CITY OF ALBUQUERQUE

RE: **Matheson Park Elementary School Site Improvements** **H21-D036**
4410 Irving Blvd. NW PE Stamp: 4/22/2013
Grade & Drain Plan for Grading, Paving and SO-19 Permits

Based upon the information provided in your submittal received 05-16-2013, the above referenced plan cannot be approved for Grading, Paving or an SO-19 Permit.

A1 MODIFIED WATER QUALITY STORM INLET DOUBLE "D"
NTS

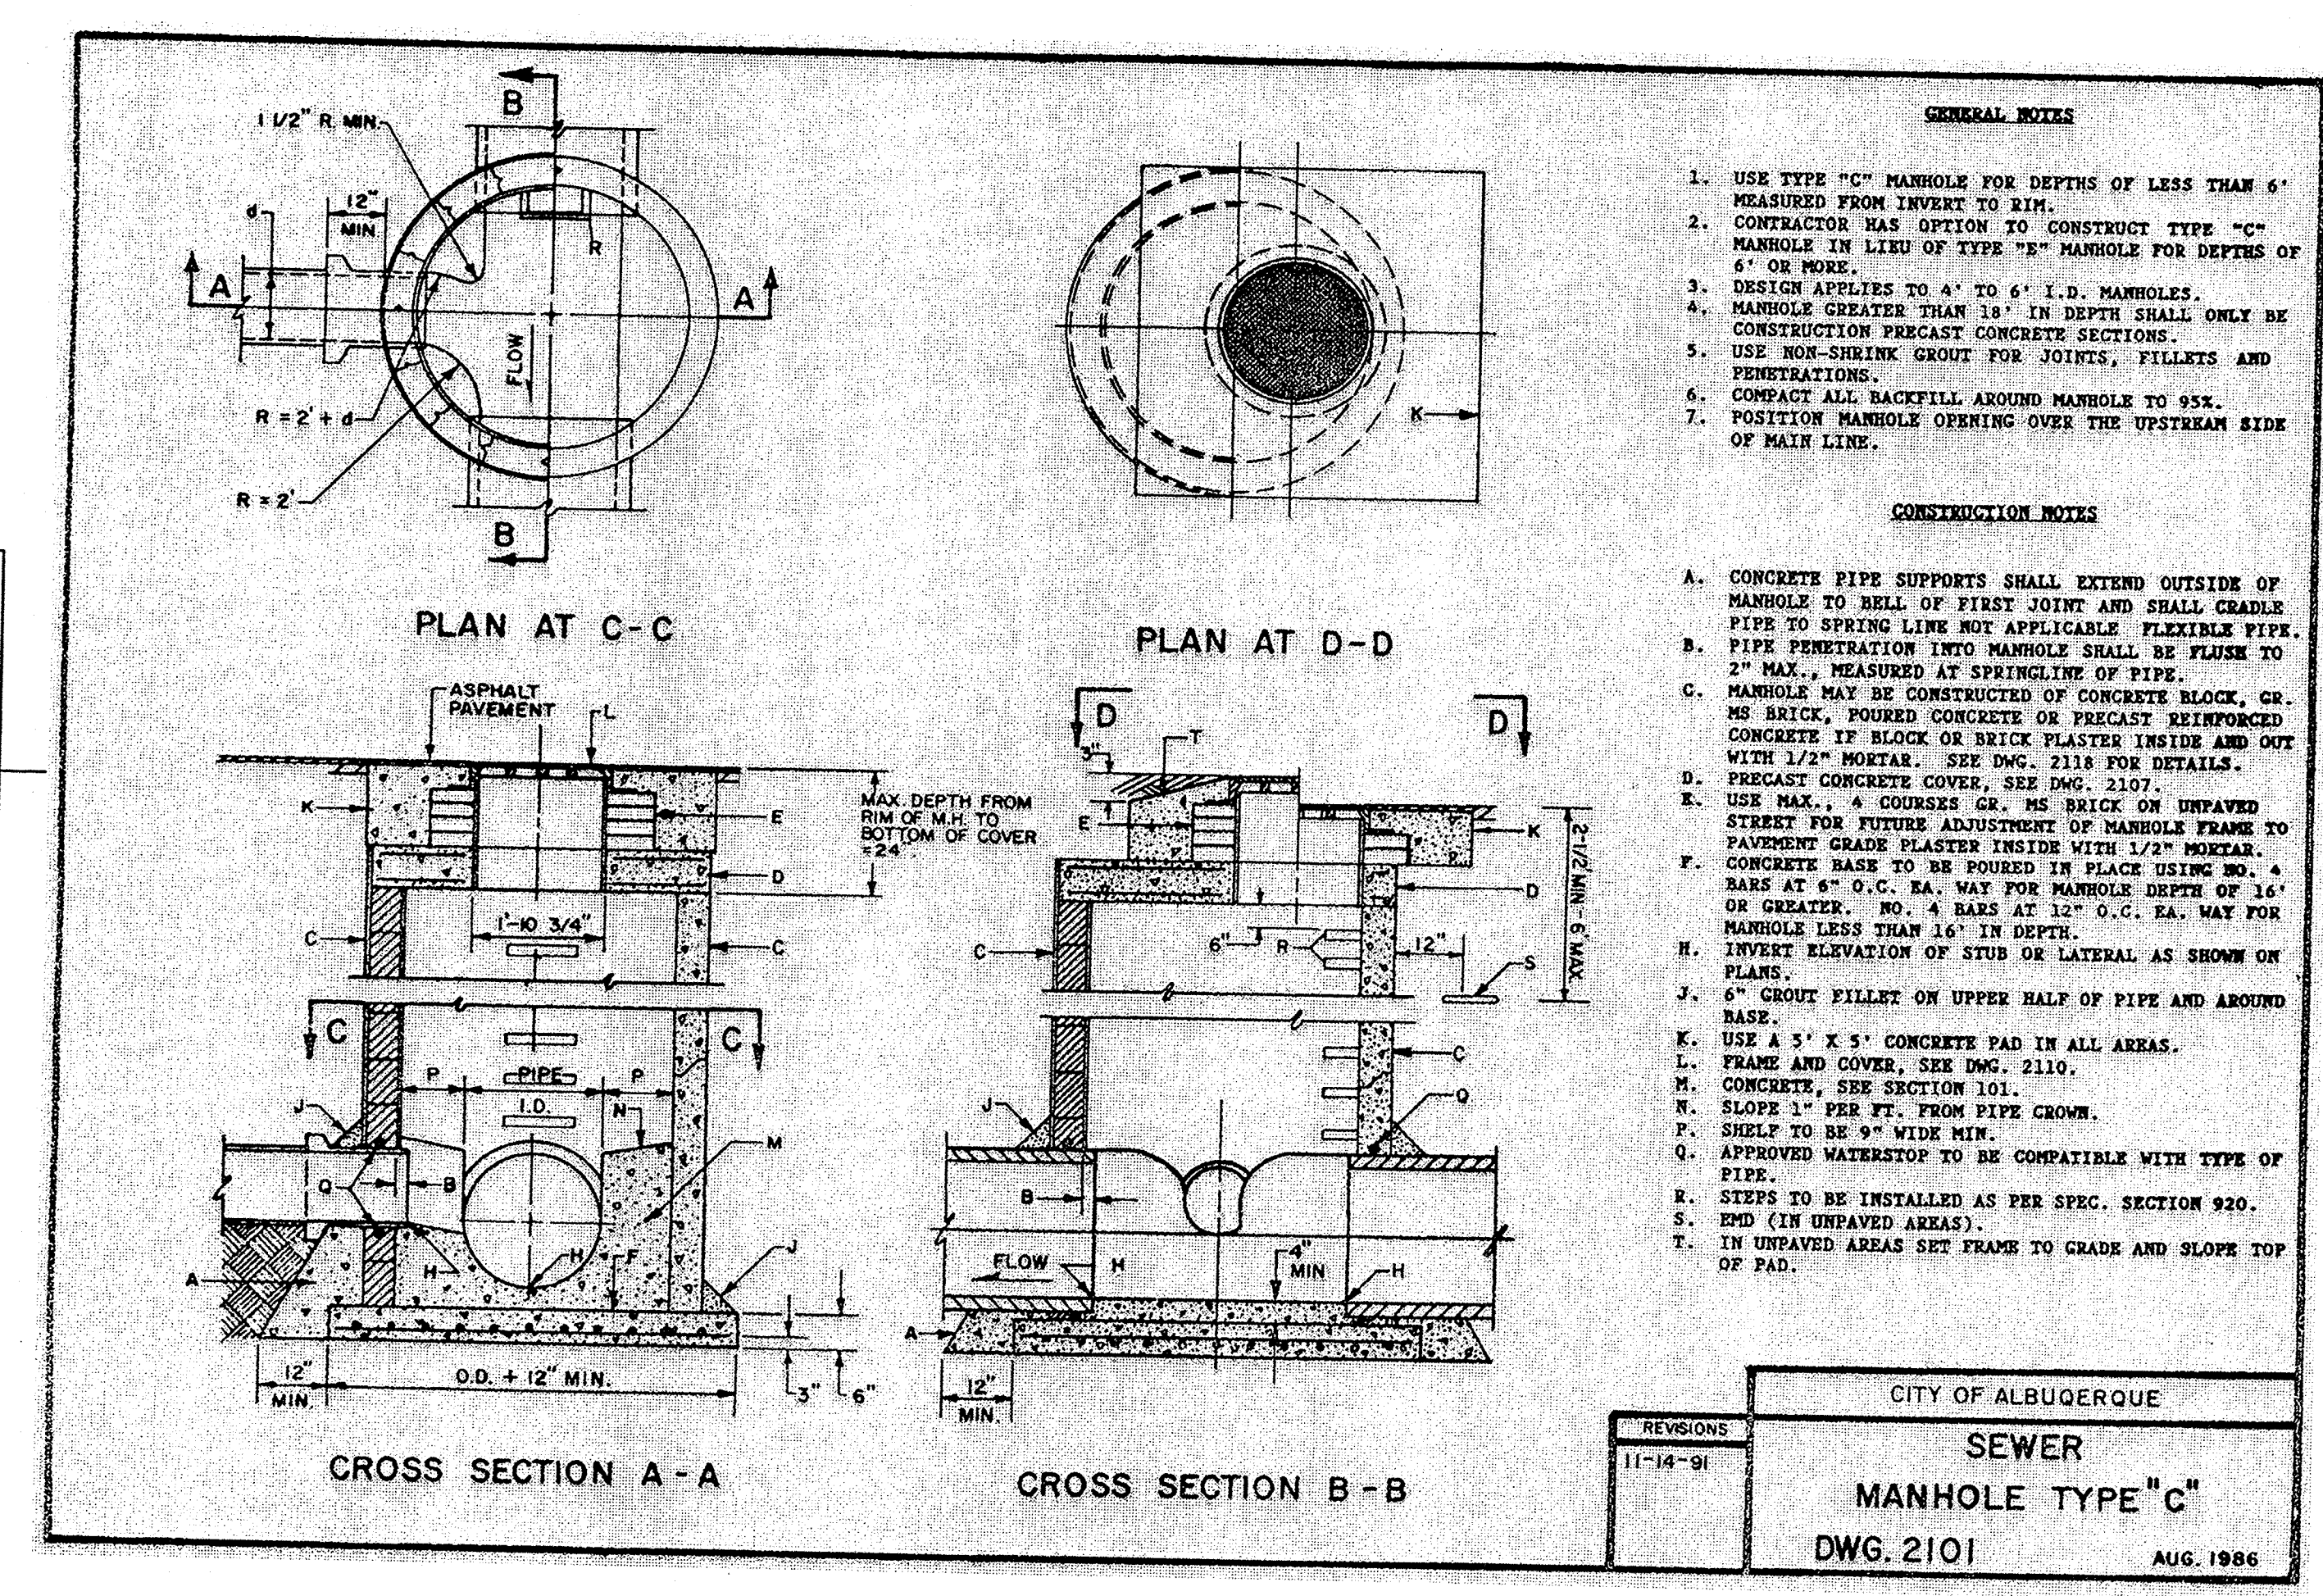
13. C-103: Key Note 1 refers to Detail A1, which is not found on C-502.
14. C-102: Key Note 5 refers to a Channel Penetration detail not found on C-502.

C3 MANHOLE TYPE "C" (COA STD DWG 2101)
NTS

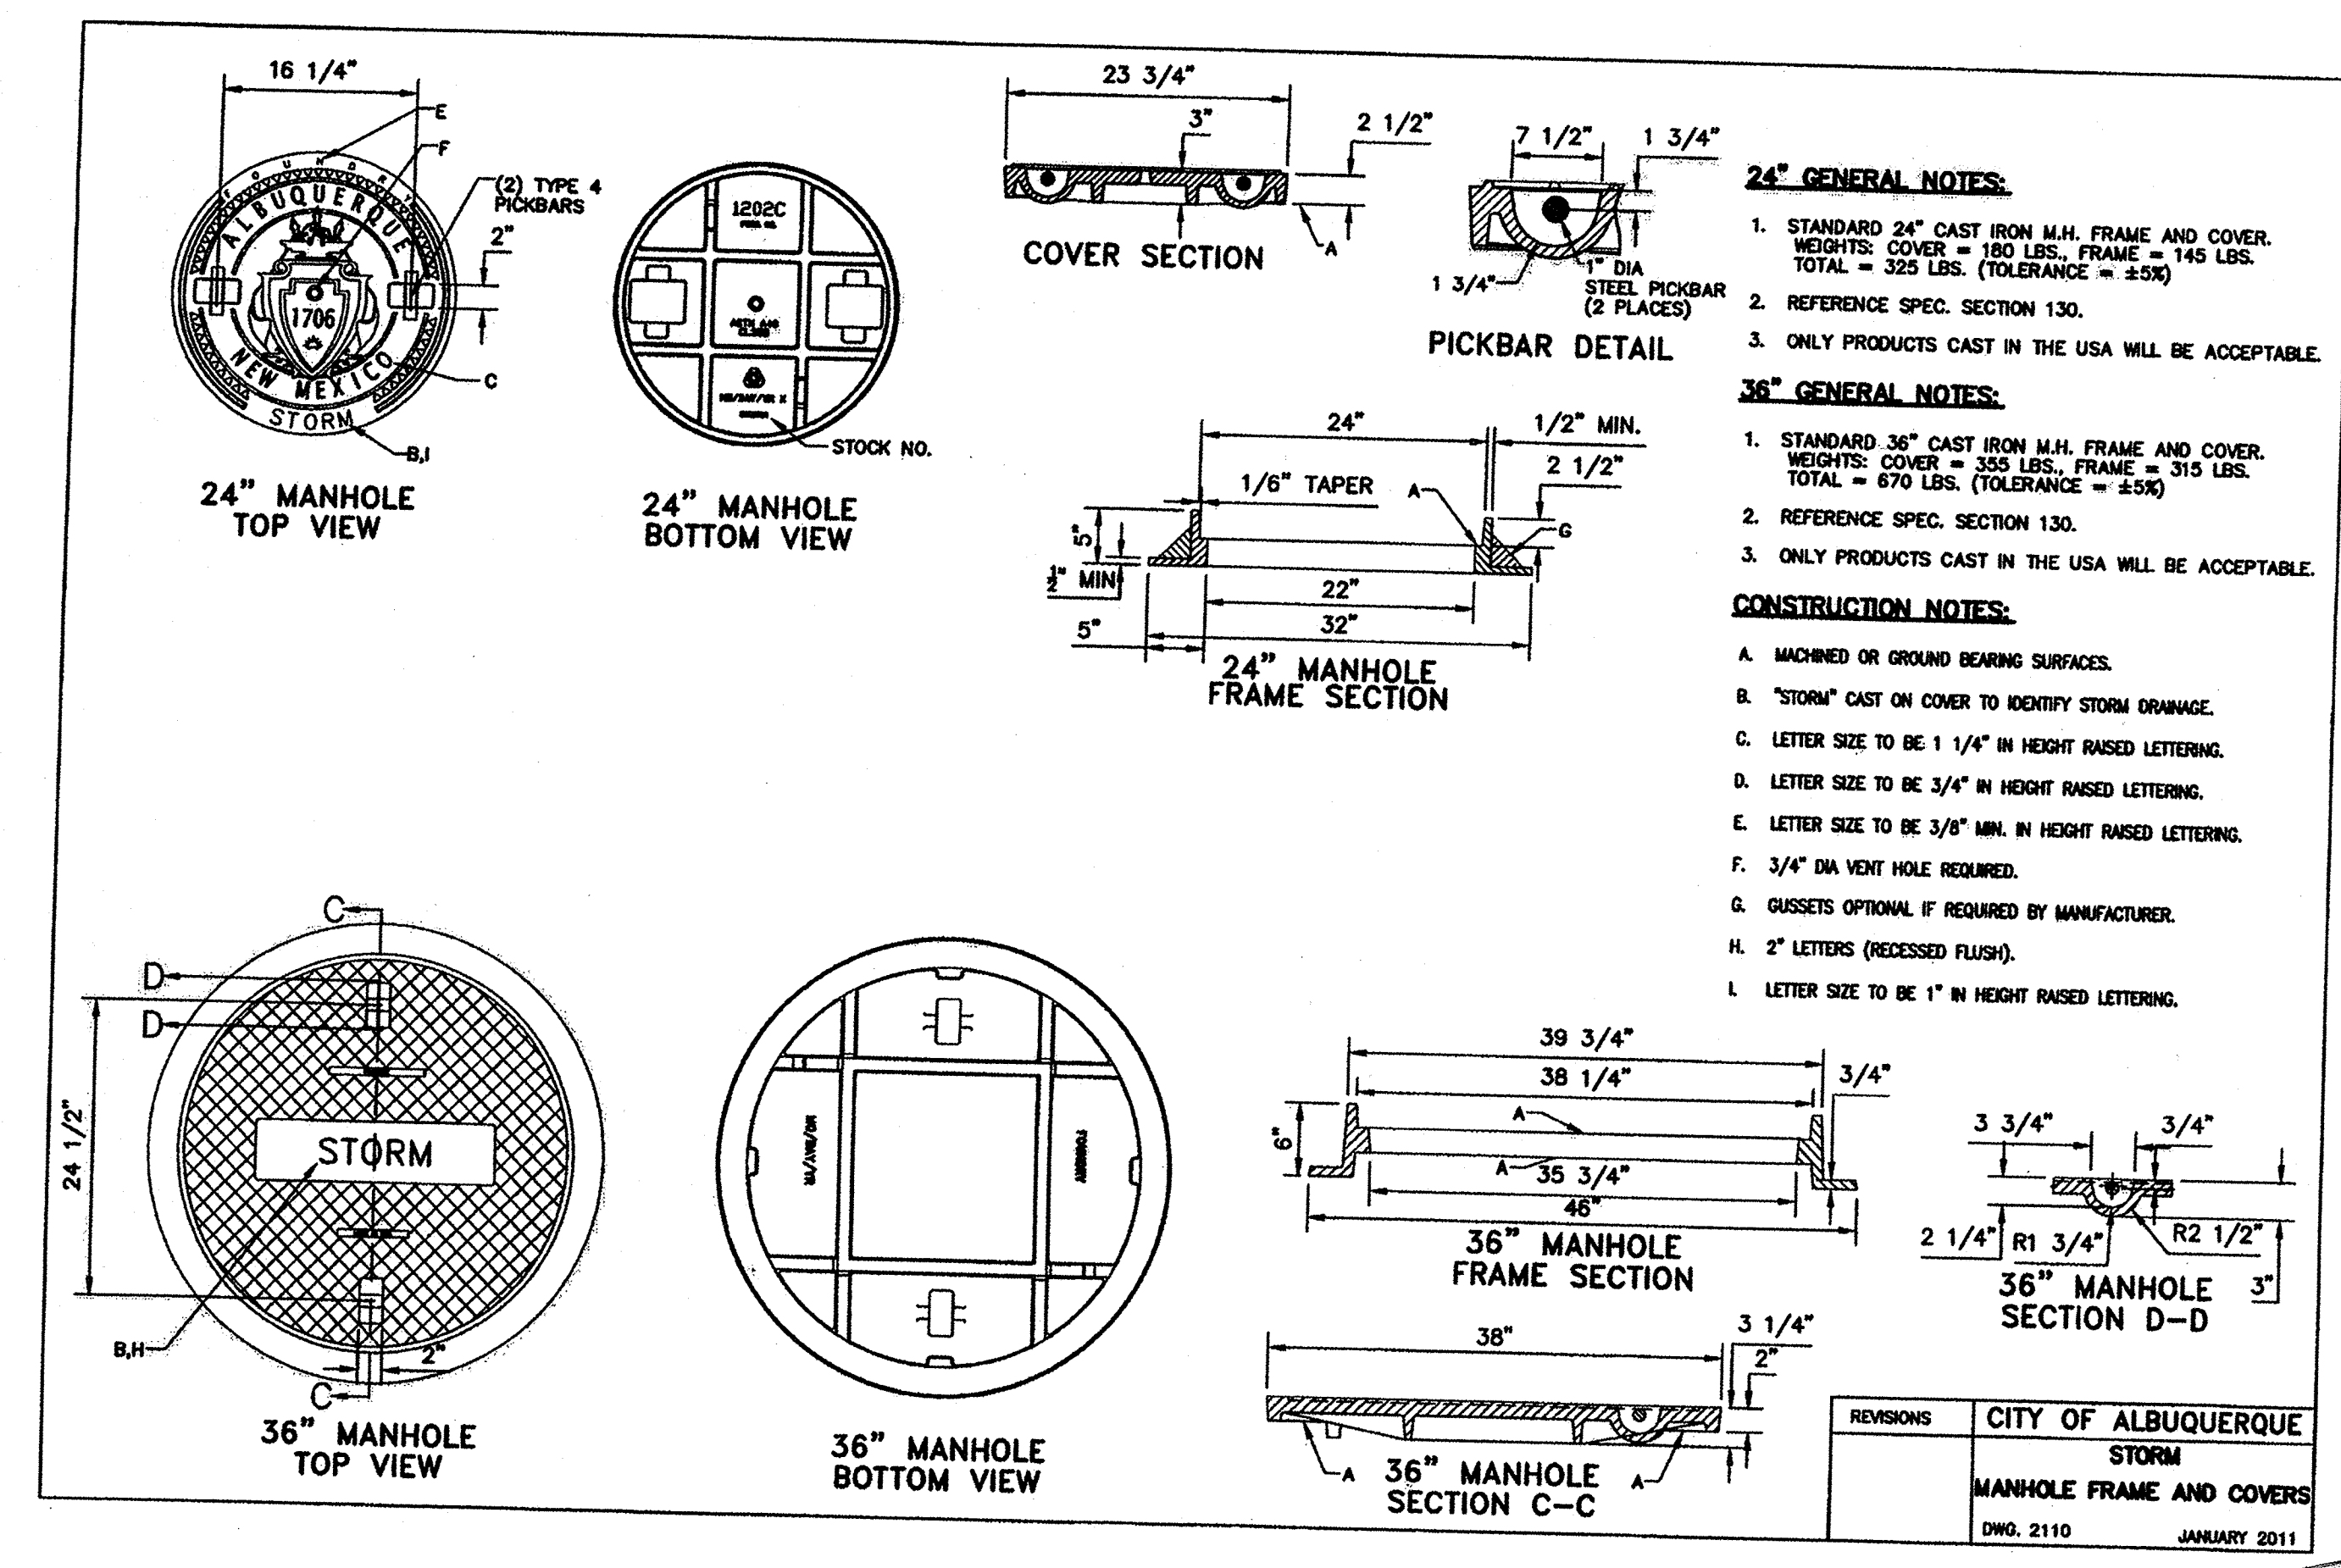
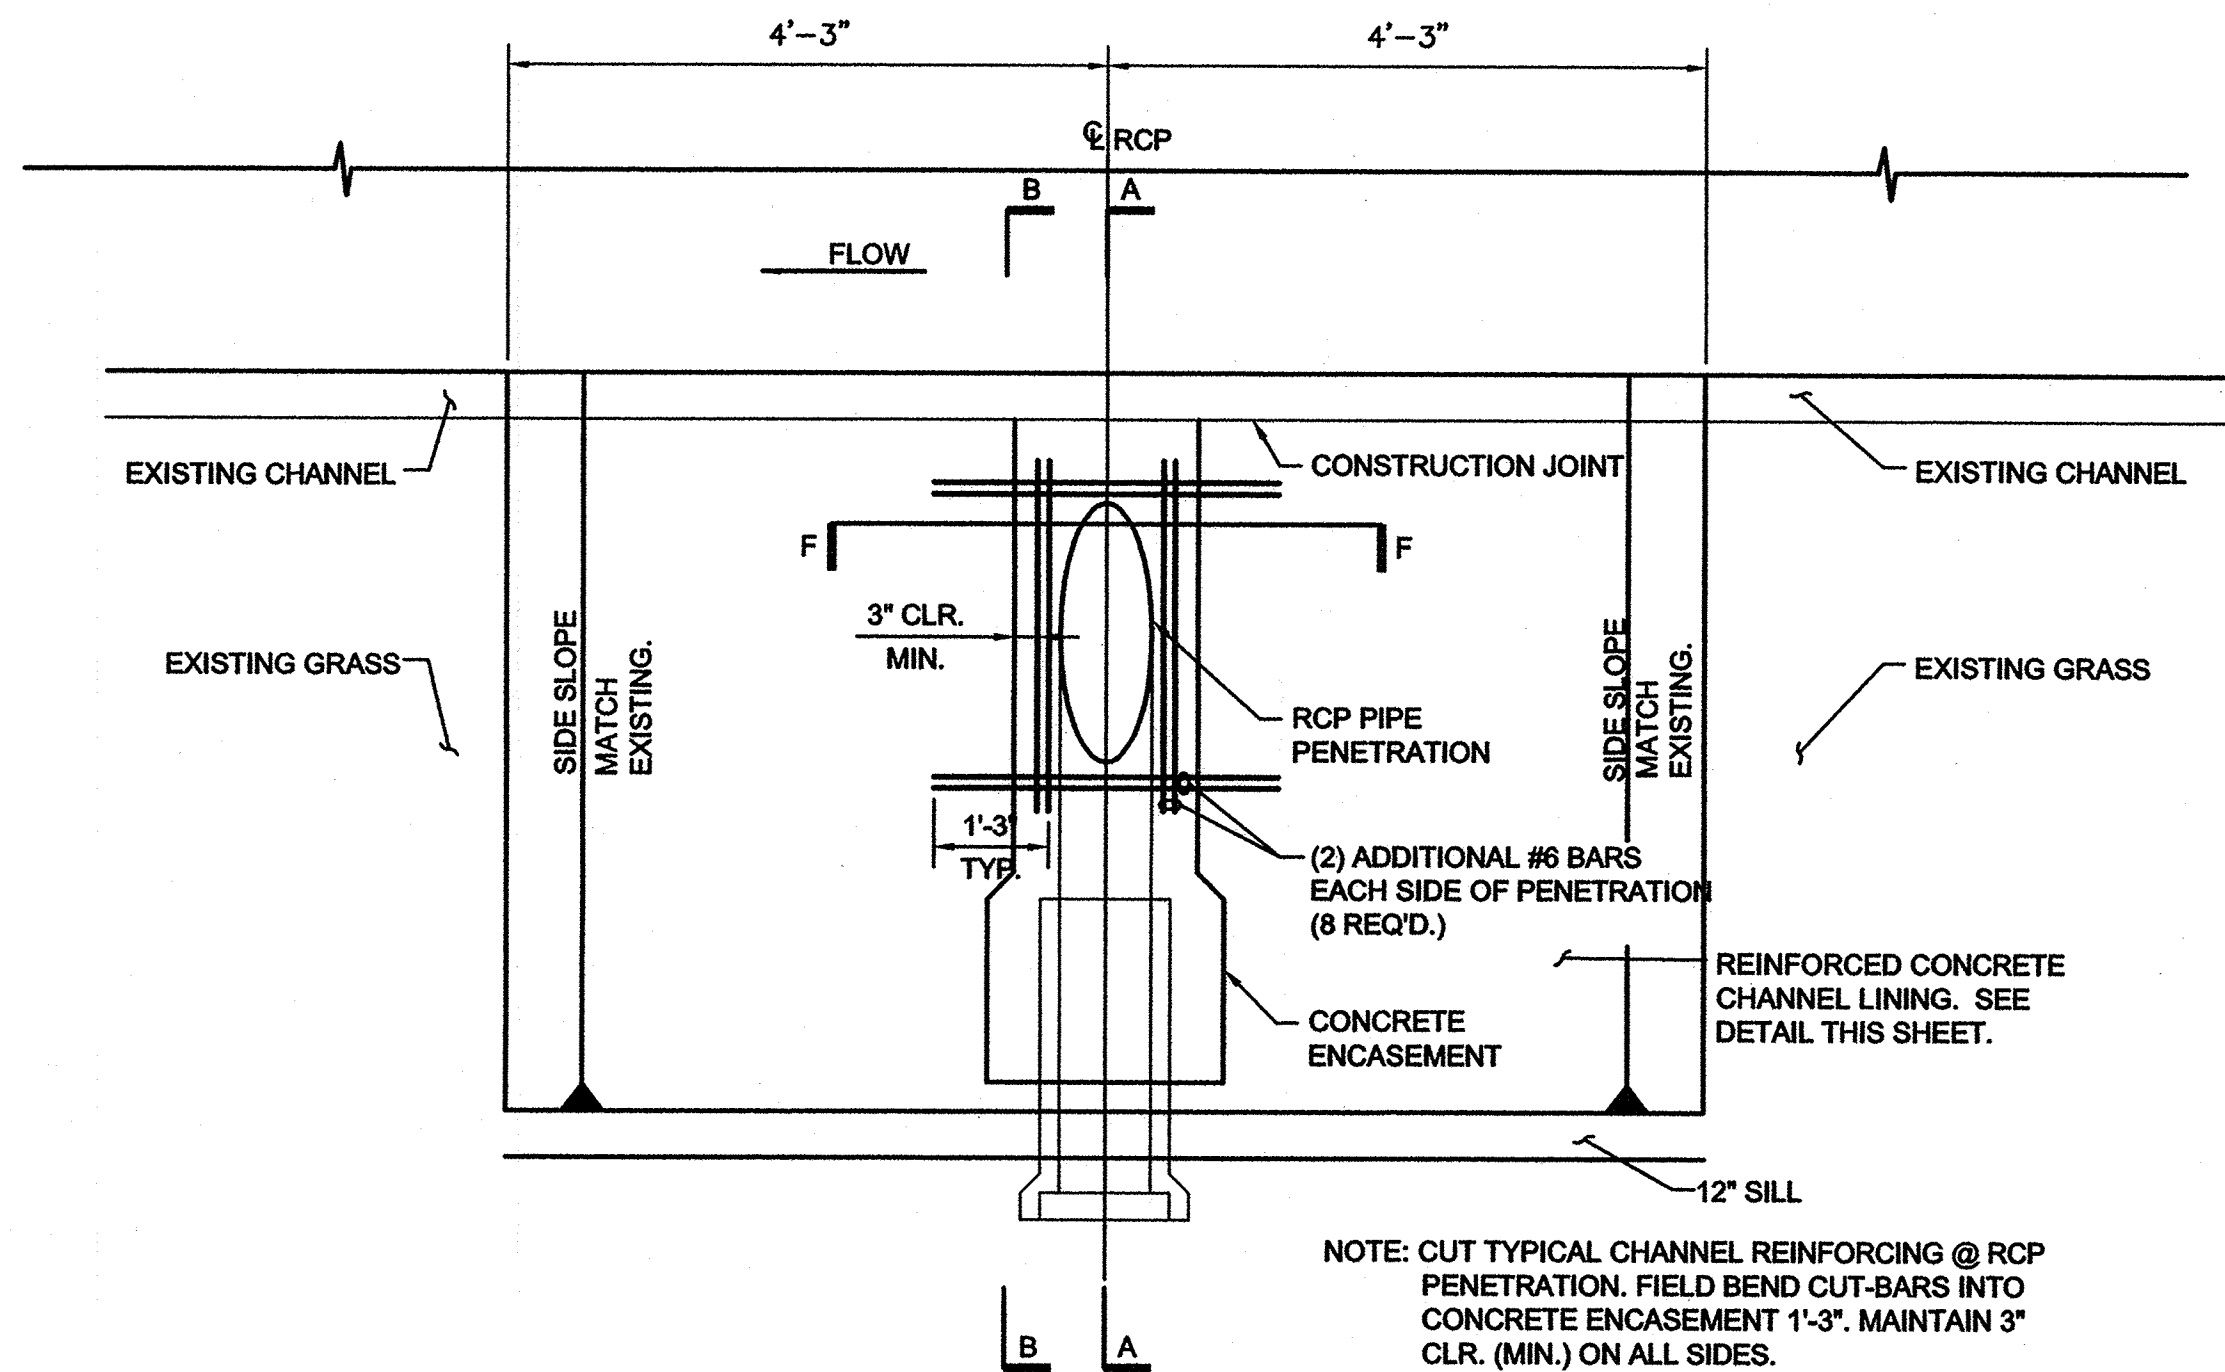
21. C-502: Similar to comment 12, above, clarify if references are to COA STND DWGS.
22. C-502: Details A3 and D3 replicate COA STND DWGS. Since the notes refer to the STND DWGS, it seems these details will not apply. What is the intent?
